23/01741/DETAIL

Address: Winter Cottage Edith Road Kirby Le Soken Essex CO13 0DH

Proposal: Reserved matters submission for 21/00201/OUT for erection of one dwelling considering access, appearance, landscaping, layout and scale.

On Behalf Of: Tree & Landscape Officer

Plan Reference Number: TQRQM23338211914419

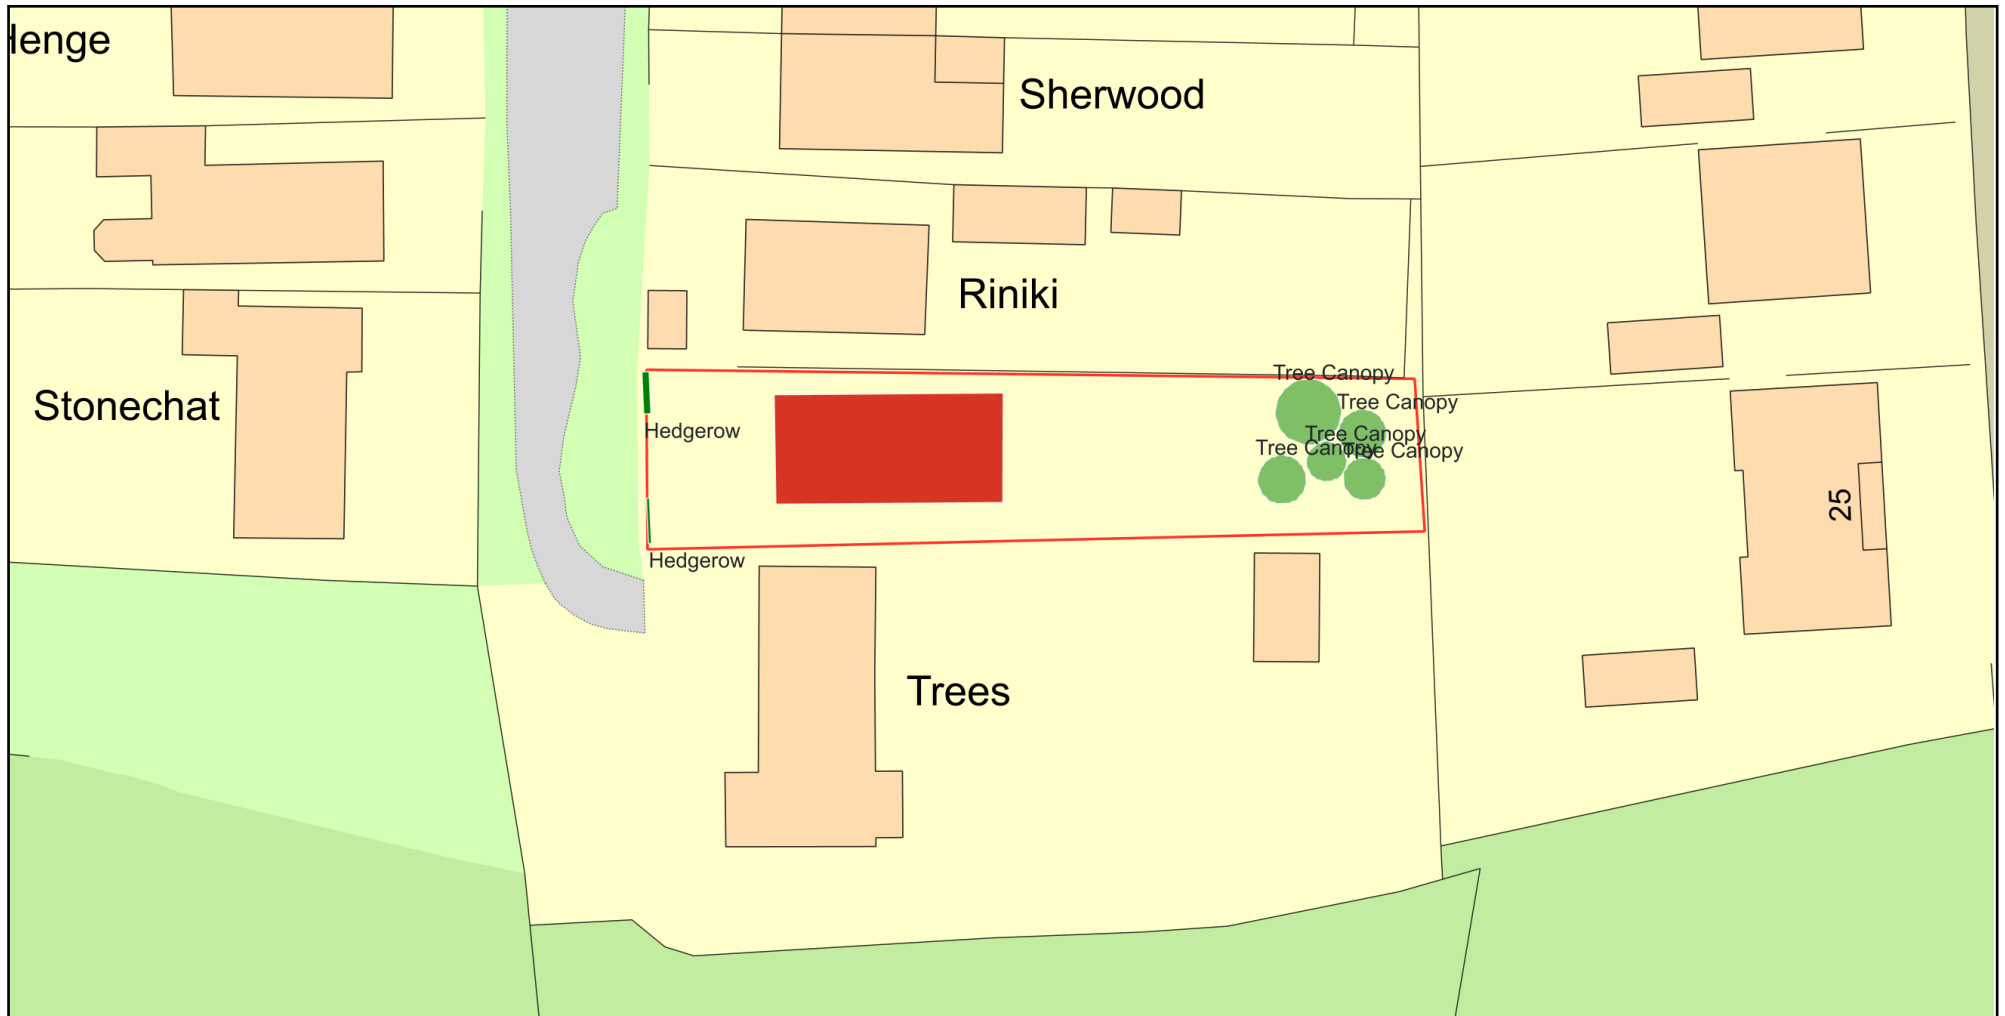
The plan submitted showing details of new planting Ref: TQRQM23338211914419 shows the position of a new hedge to be planted on the boundary of the front garden with the highway but does not include details of plant species, specification, or quantity. This information will be necessary prior to the determination of the application.

Acceptable species would be Yew (*Taxus baccata*), Privet (*Ligustrum ovalifolium*) or Laurel (*Prunus rotundifolia*). Many other species would be equally acceptable.

Plants should be 60 to 90cm tall if bare rooted or supplied in a container with a minimum capacity of 3 litres.

Plants should be planted at a spacing of 2 per linear metre.
